R-2511 4B Interagency Concurrence Point Meeting Minutes

Date: April 18, 2018

The 30% Hydraulic Review was held in order to reach agreement on concurrence point 4B for the R-2511 US-17 widening project in Beaufort and Martin Counties. The following items were discussed and conclusions reached:

PROJECT REFERENCE NO. R-2511		SHEET NO. 30	
RW SHEET NO.			
ROADWAY DESIGN ENGINEER 		HYDRAULICS ENGINEER 	
DOCUMENT NOT CONSIDERED FINAL UNLESS ALL SIGNATURES COMPLETED

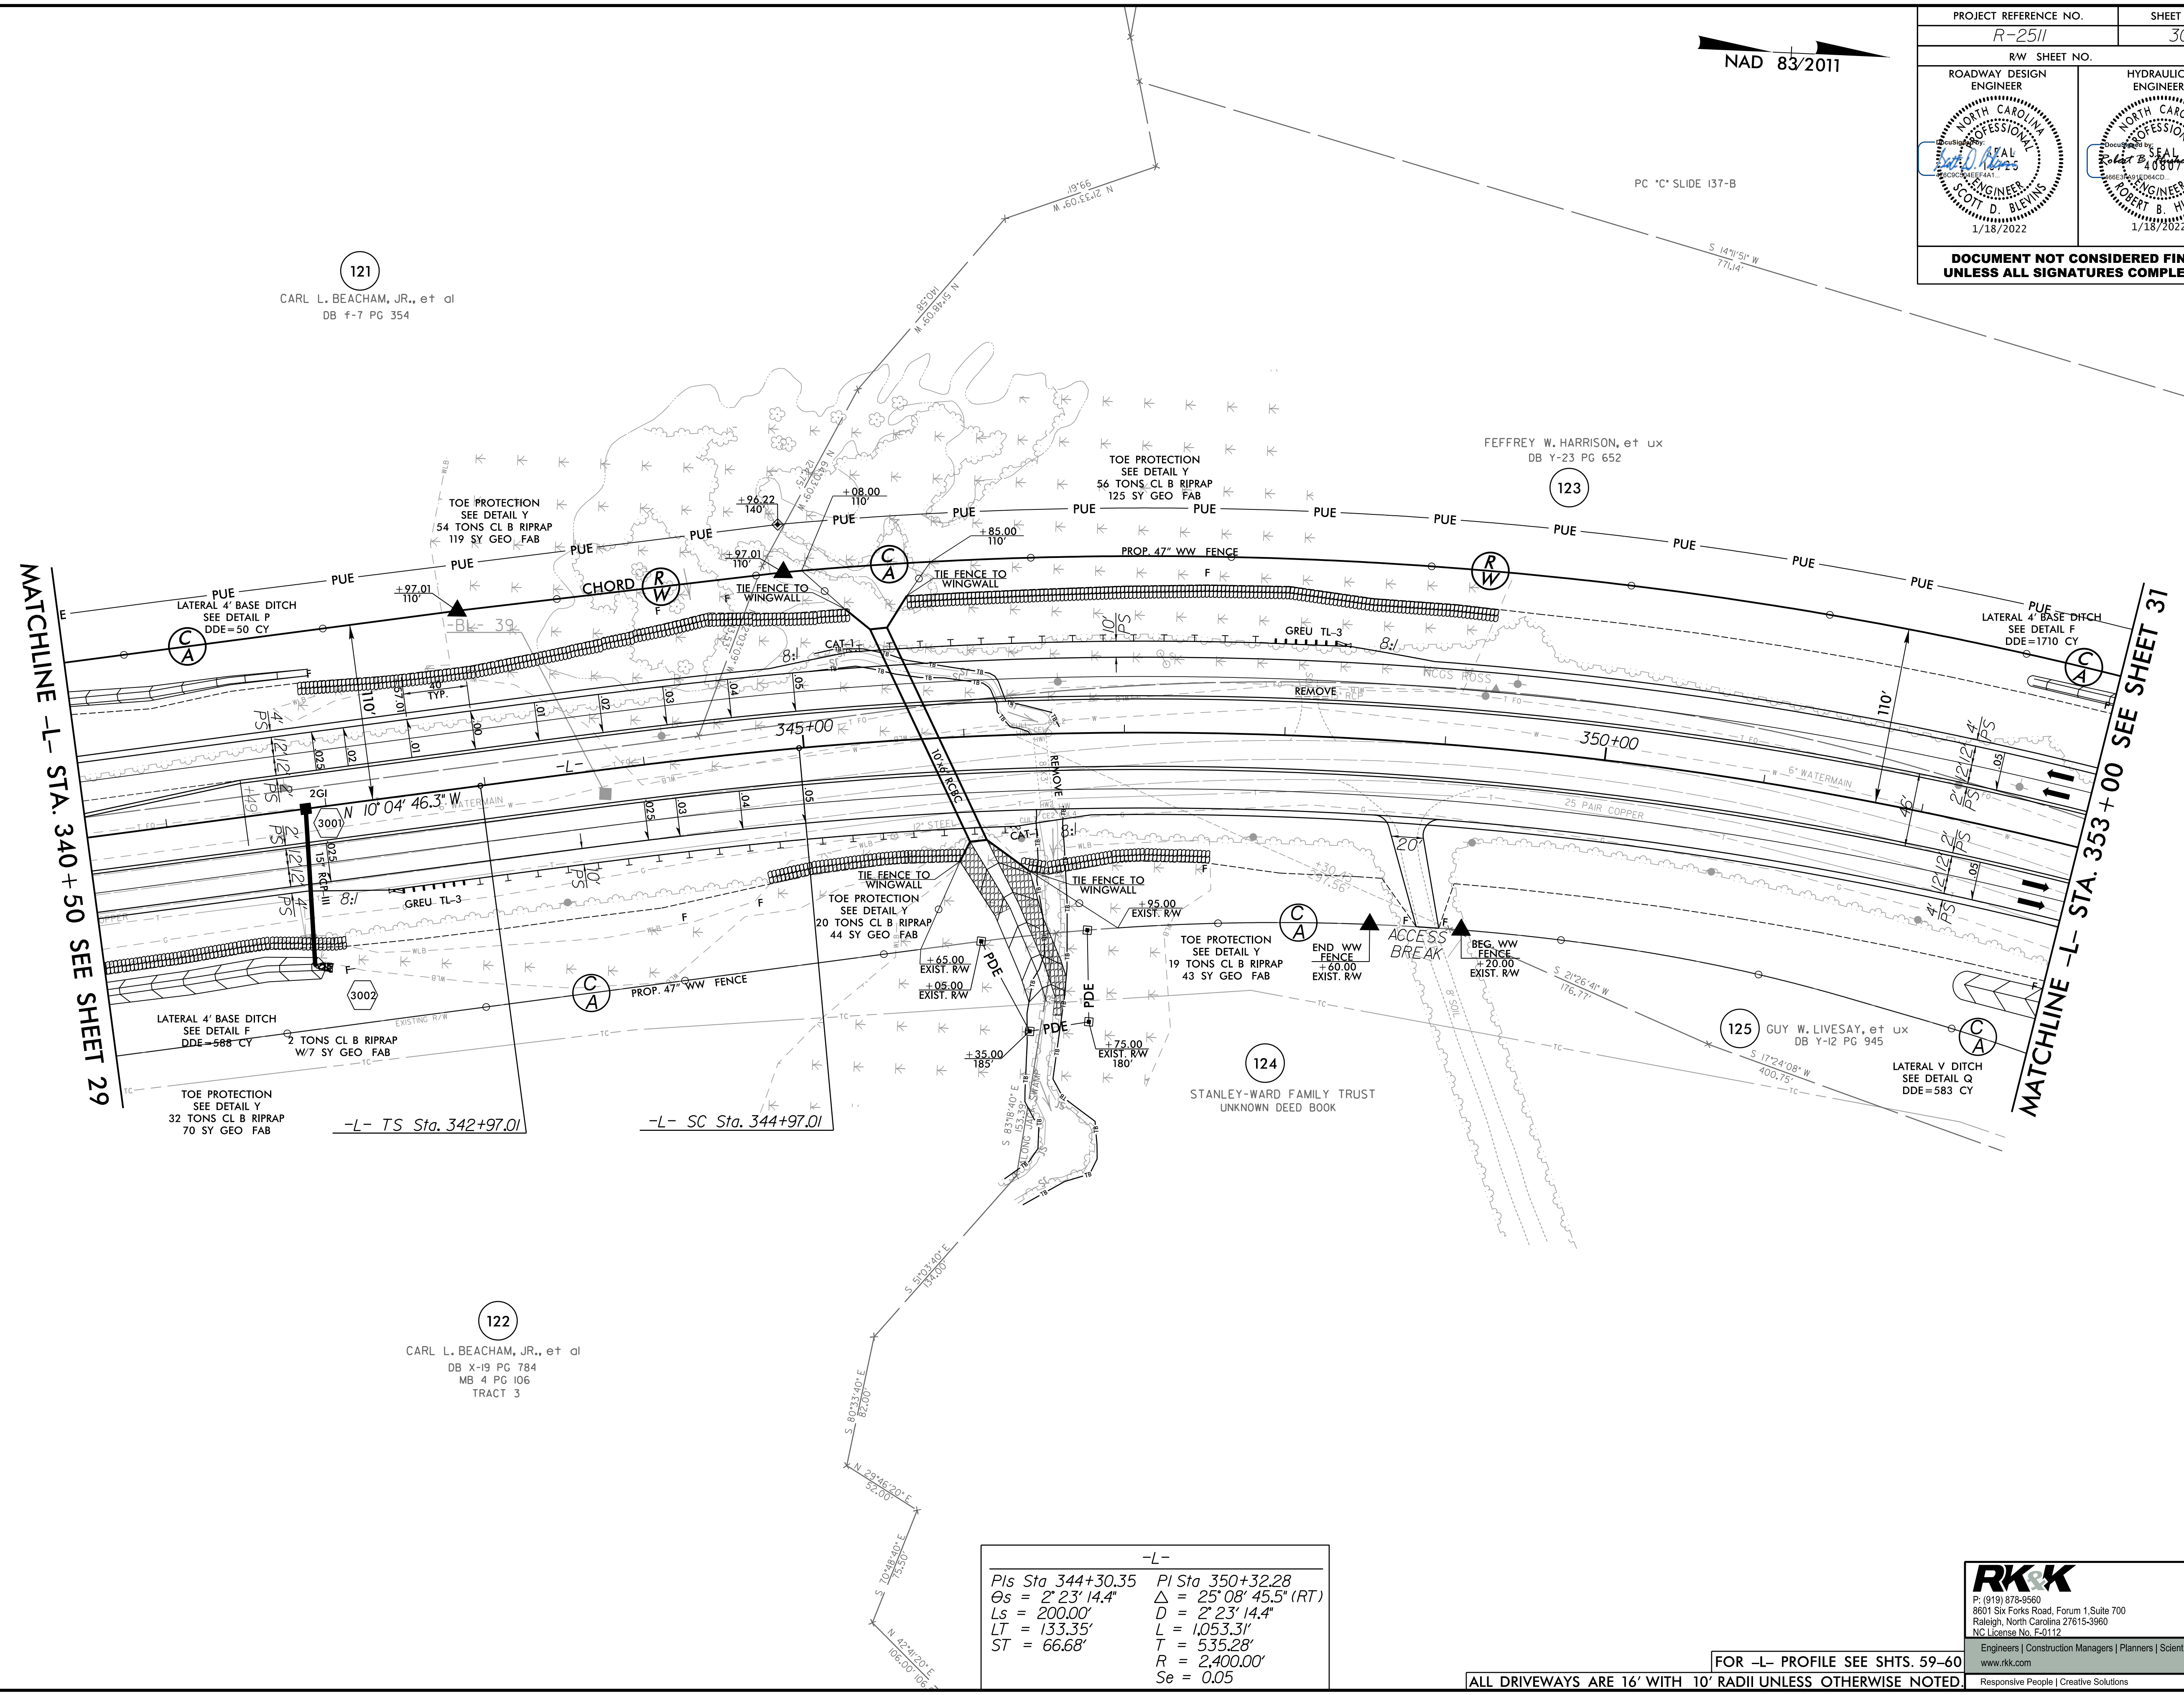
Plan sheet 30 (Stream Jacks Swamp Creek SE, wetland WF): Jacks Swamp runs west to east through the project and is currently conveyed in an 8'x3' RCBC at -L- 346+50. There will be wetland impacts up and downstream of the crossing. The 8'x3' RCBC will be removed and replaced with a 10'x5' RCBC buried 1.0' in the final condition. Mr. Cook stated that the design team is still looking at this crossing, and he presented four different options that the team is looking at for aligning the proposed culvert. The four options were as presented (and attached to these minutes): 1) aligning the culvert as shown in the 4B plans crossing at -L- 344+50 at 90° and adding an outlet channel that runs for 200' parallel to the roadway facility before tying to the stream; 2) aligning the culvert at -L- 344+75 at 70°, while leaving the inlet in the same location as option 1, and adding an outlet channel that runs for 150' parallel to the roadway facility before tying to the stream; 3) sliding the culvert up station (from options 1 & 2) and providing approx. 100' channel to the inlet with the crossing at -L- 345+75 at 70° and adding 100' +/- tail channel that gradually ties to the stream; 4) providing approx. 200' channel to the inlet running parallel to the roadway and replacing the existing culvert in the same location, crossing at -L- 346+50 at 90° and tying the outlet of the culvert to the existing stream channel.

Mr. Cook stated that the design team is in favor of options 1 and 2 since the inlet end of the culvert is being placed in the low flow pattern and the center of the natural flow direction of the crossing even though an outlet channel must be constructed that will impact wetlands. Mr. Cook stated that options 3 and 4 are not as favorable due to the fact that it would be hard to tie to the low flow area to the proposed RCBC since there really isn't a true channel to tie to. Potentially scour could also occur in the new fill slope at the location where the new channel would tie to the low area due to the sharp angle the flow would need to take. Mr. Cook stated that once an alignment is decided for the proposed culvert the model will be able to be completed since hydraulics of this culvert works together with the next site up that crosses US 17; 2,150' farther up station. This will be called out as site 8. Mr. Ward and Mr. Barnes stated that they will be going back to this site to do field verification for the JD when the site is in dryer conditions. The design team will wait for the JD field verification to move forward with the culvert design.

PROJECT REFERENCE NO. R-2511		SHEET NO. 36	
RW SHEET NO.			
ROADWAY DESIGN ENGINEER SCOTT D. BLEVINS 1/18/2022		HYDRAULICS ENGINEER ROBERT B. HUSKEY 1/18/2022	
DOCUMENT NOT CONSIDERED FINAL UNLESS ALL SIGNATURES COMPLETED

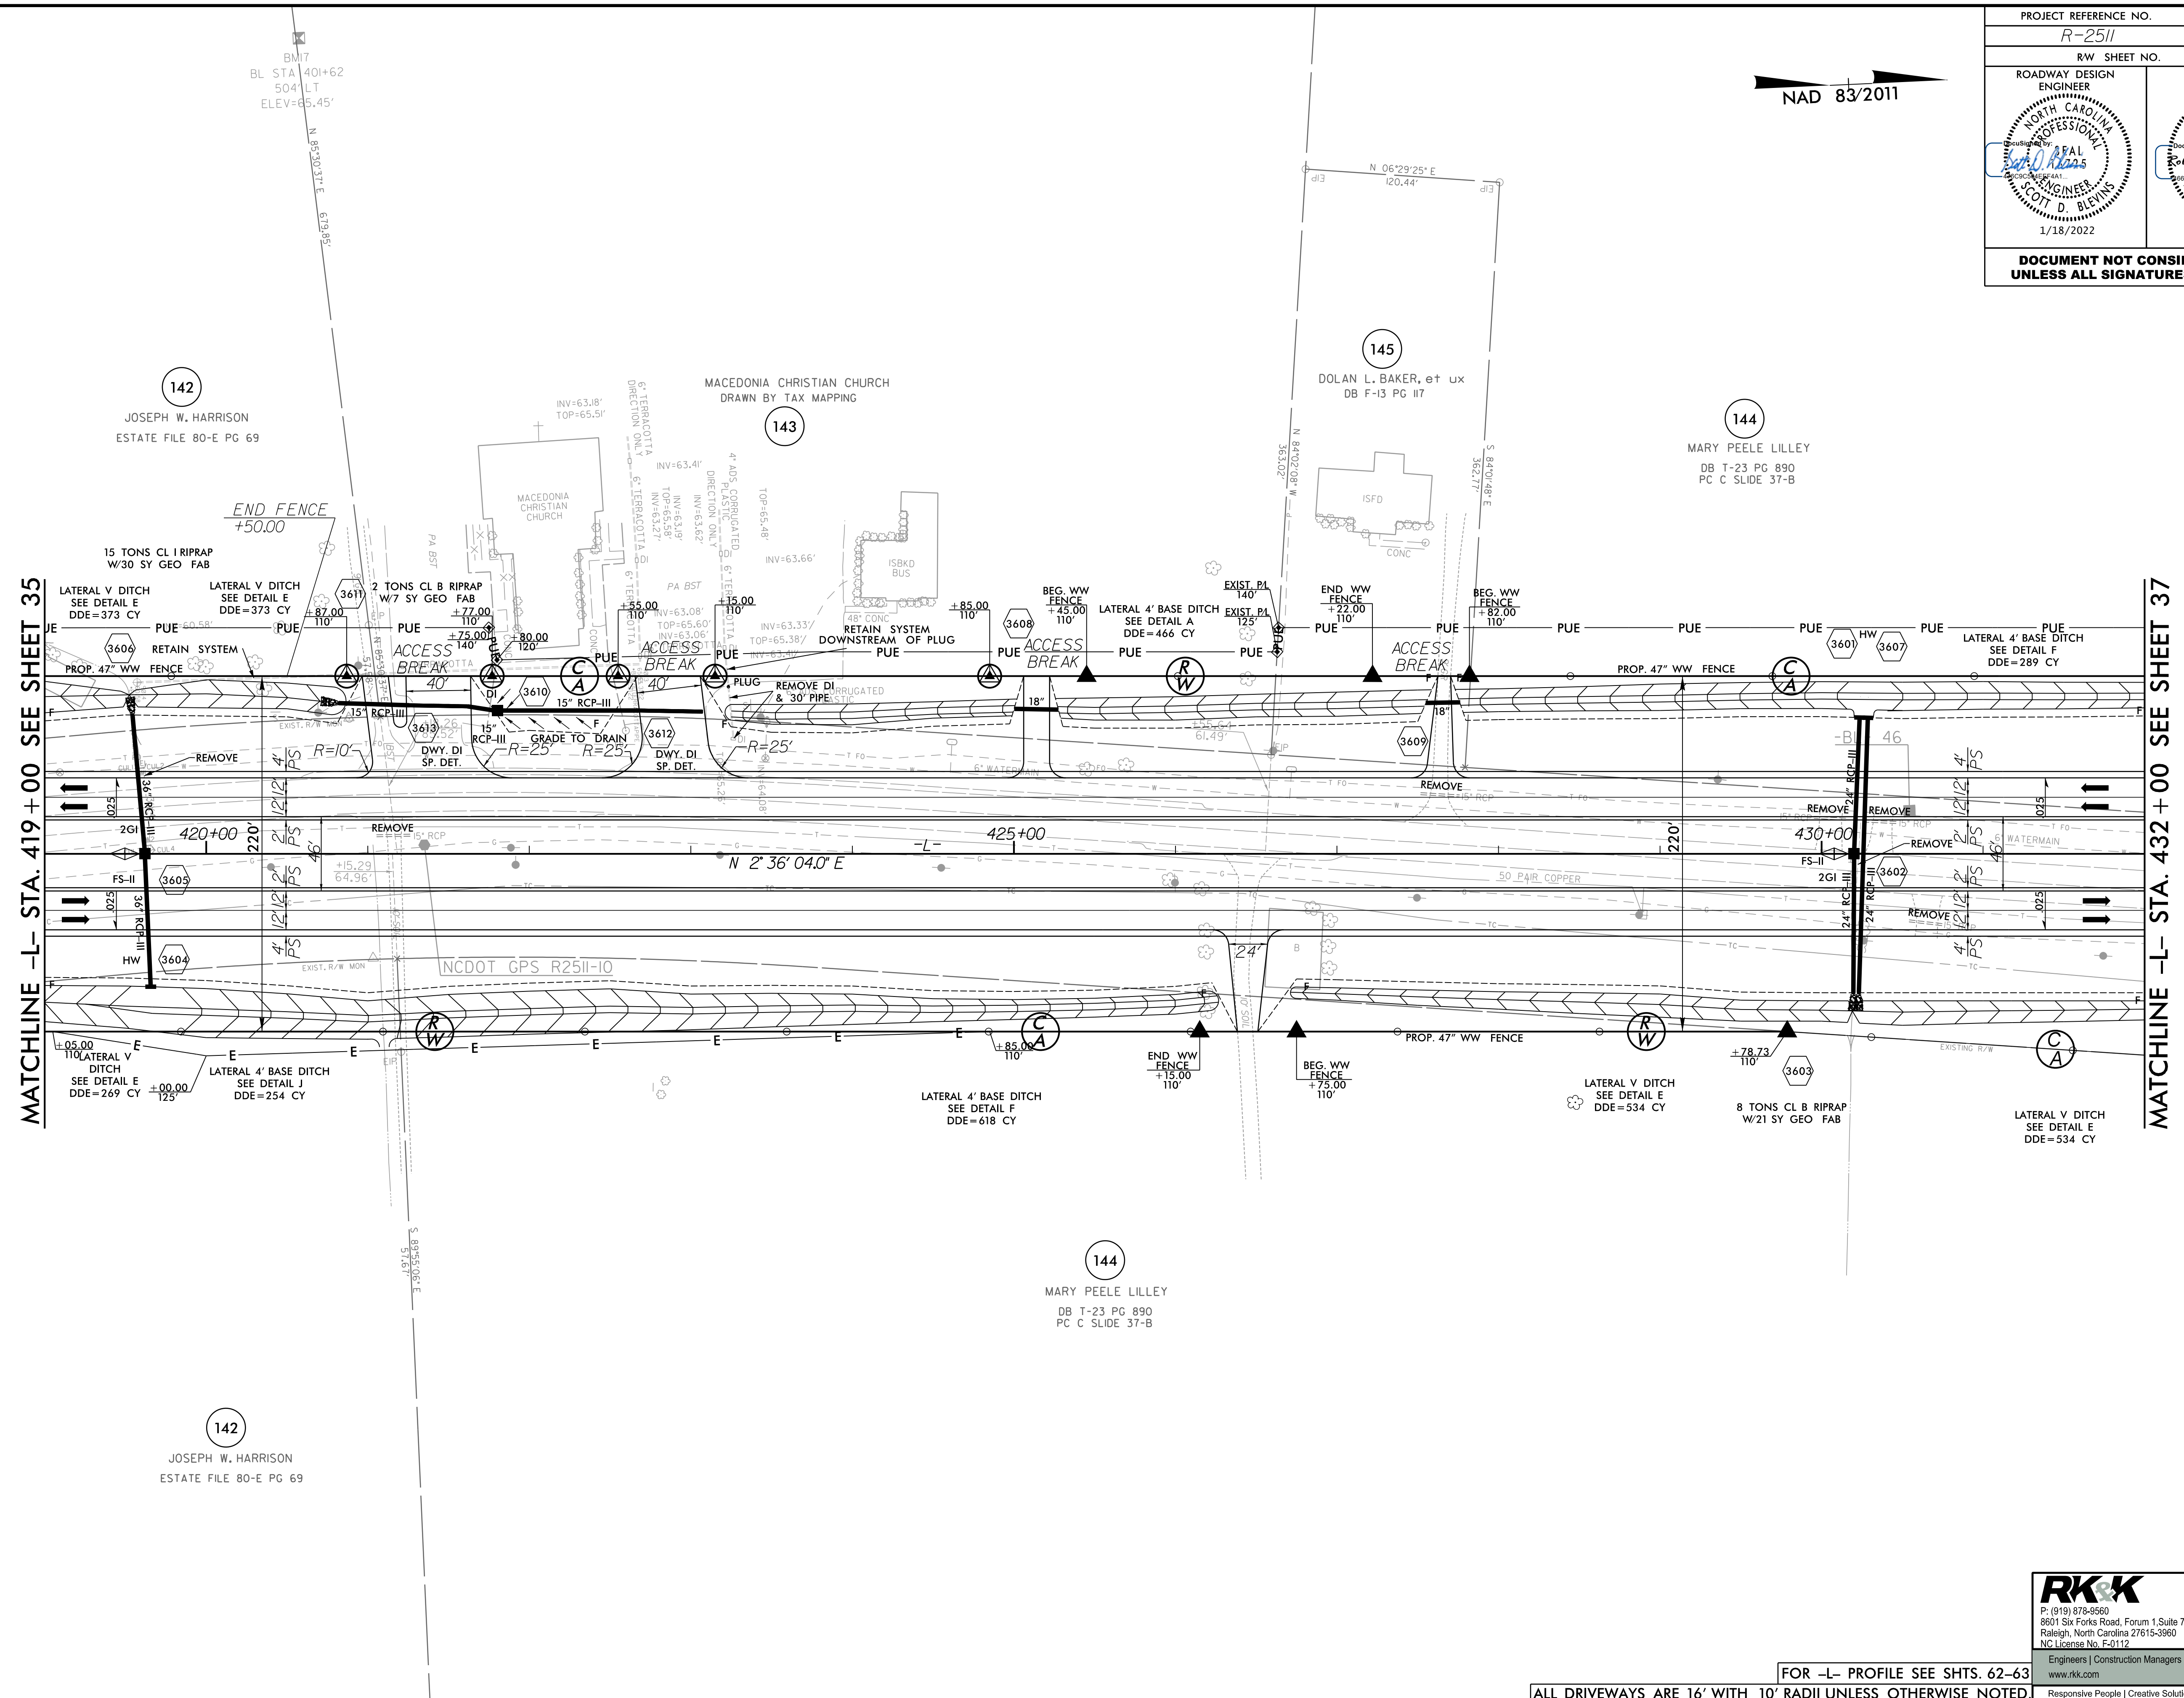
Plan sheet 33-37: There are no surface water or wetland impacts on these sheets. On plan sheet 36, Mr. Abel asked if the design team could remove the ditch in front of the Macedonia Christian Church from approximately -L- STA. 421+00 to 422+50 LT. He stated that NCDOT wants to minimize impacts to the property of the church. Mr. Cook said that the design team will remove the ditch.
